Rezoning Transportation Analysis

Petition Number: 2020-112

Revision Log:

Date	Description
09-11-20	First Review (EL)
04-15-21	Second Review (EL)
8-25-21	Third Review (BB)
9-21-21	Fourth Review (BB)

PROPOSED PUBLIC ROAD D

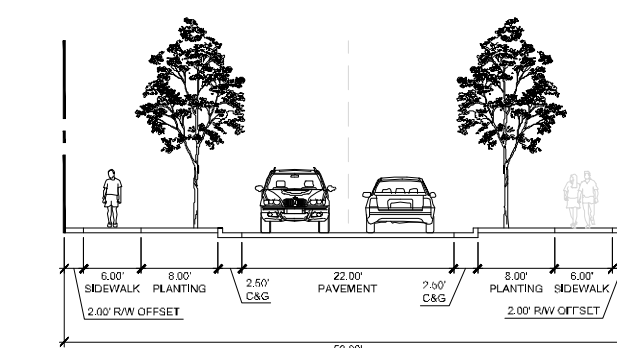
5. **Outstanding (Site plan dated 8/16/21):** Revise "Proposed Public Road D" cross-section to include a 6' bike lane. The site plan and conditional note(s) need to establish a street connection, as shown below, according to the proposed avenue cross section that is recommended within the University Research Park Area Plan. Refer to pages 38 and 41.
